DECISION DELEGATED TO DEVELOPMENT MANAGER

Application No:	H16-0868-19	Applicant:	Tanglewood Care Homes Ltd
Proposal:	Proposed Annexe Buildings		
Location:	Tanglewood Cedar Falls Little London Spalding		
Terminal Date:	17th January 2020

Drawing
PROPOSED ANNEXE BUILDINGS.
SITE PLAN - PROPOSED
LOCATION PLAN

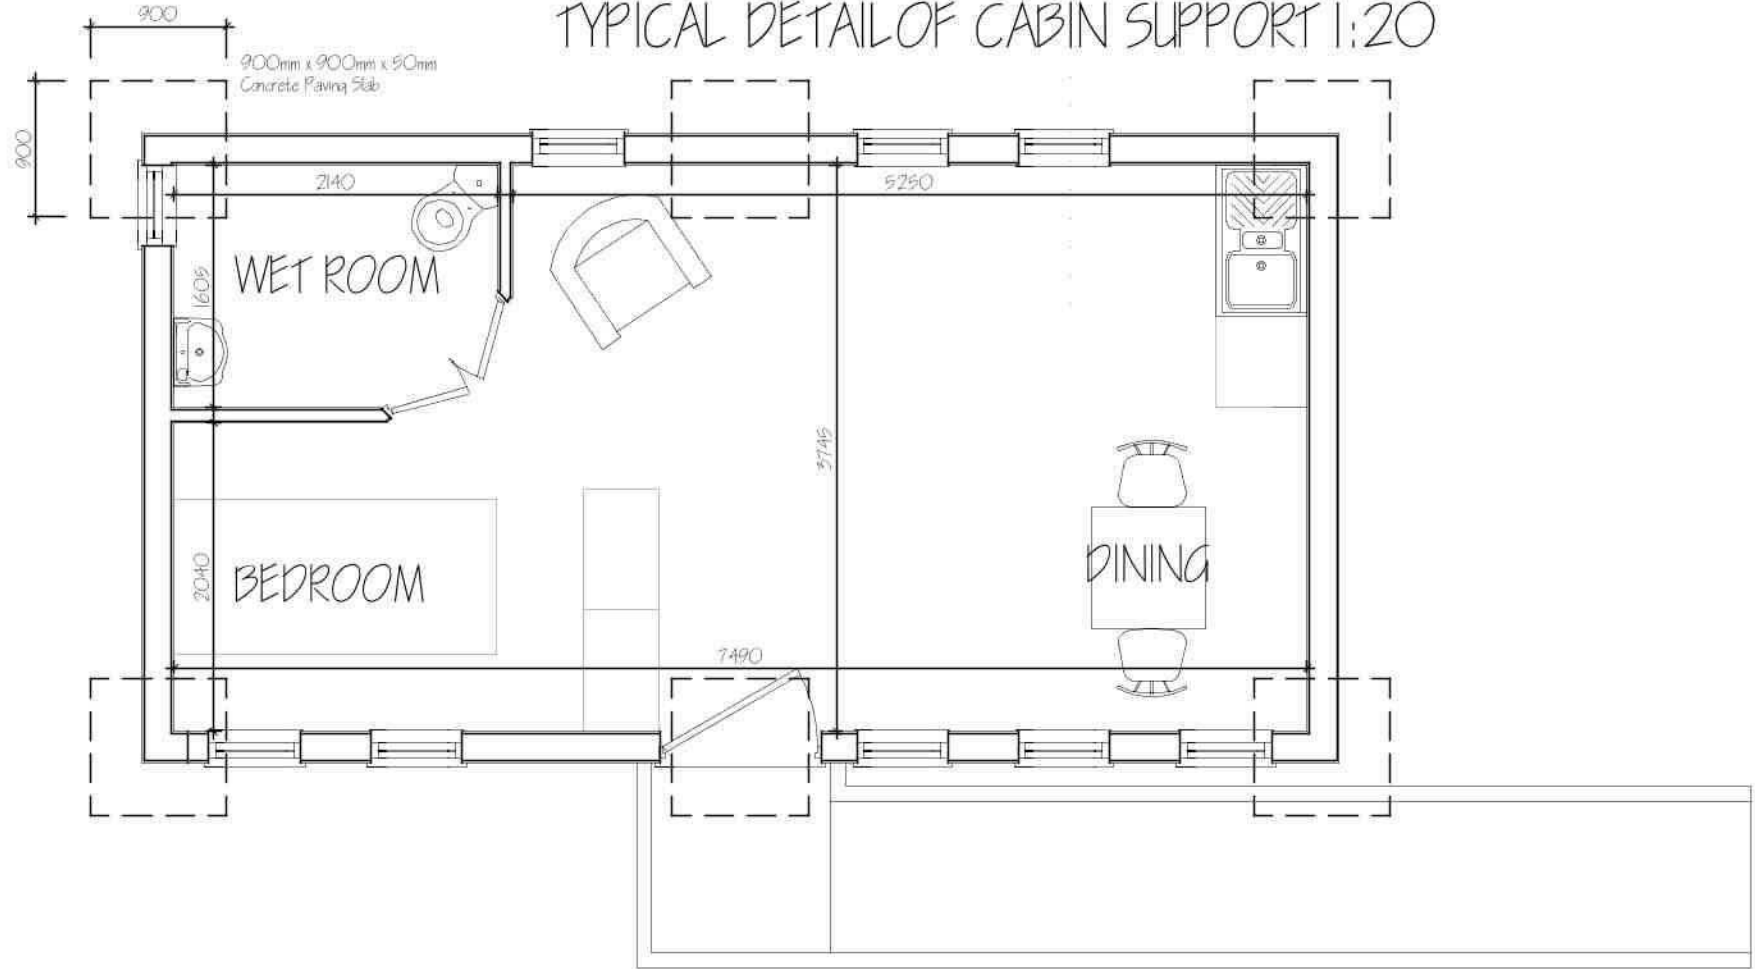
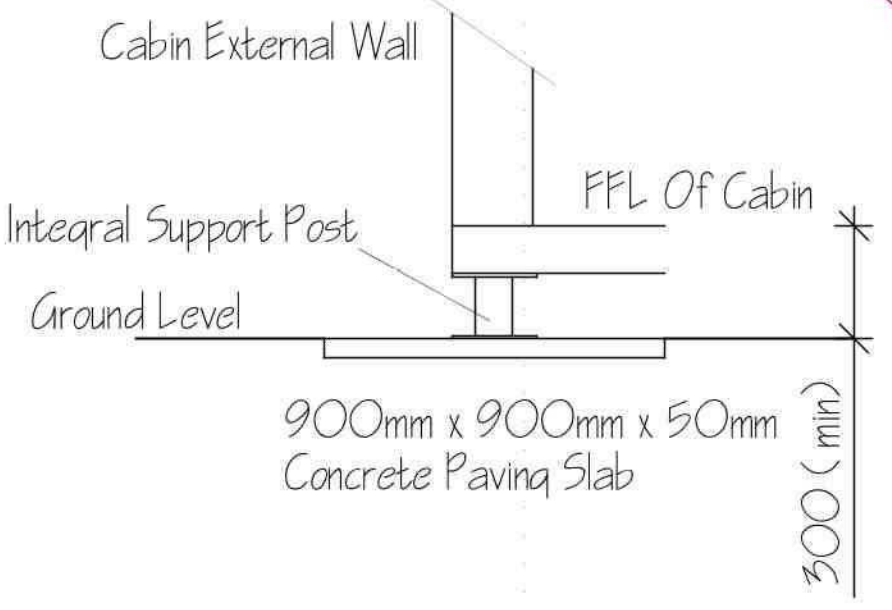
In British Standard (BS) 5837:2012 '5.3.1 The default position should be that structures (see 3.10) are located outside the Root Protection Areas (RPAs) of trees to be retained. However, where there is an overriding justification for construction within the RPA, technical solutions might be available that prevent damage to the tree(s).' In this instance there is no 'overriding justification for construction within the RPA'.

The infrastructure to support the log cabins and their residents are likely to be very damaging to the trees. Wet rooms do not exist without pipes to take the water away, by the nature of drainage this will involve excavations within RPAs, similarly the toilets, and sinks all connect to underground pipework as do gutters.

The form of the development however would be under the management of, but physically unconnected to, the host building, and as such is more appropriate to be considered to be a *highly vulnerable* use, particularly at any time of emergency, when the cabins may not be accessible to the staff located within the host building if evacuation proves necessary.

The buildings would be located beneath the canopies and over the root systems of trees covered by a Tree Preservation Order.

As can be seen from the consultation response above from the Council's Conservation Assistant (Tree Preservation), this application would not provide a form of development that can be accommodated within this location, a result of the impact it would have upon the trees. These trees provide a healthy and valuable contribution to the wider public realm as well as the setting of the host building. As a result of the considerations of the Conservation Assistant (Tree Preservation), this application is recommended for refusal by reason of detrimental impact on trees.
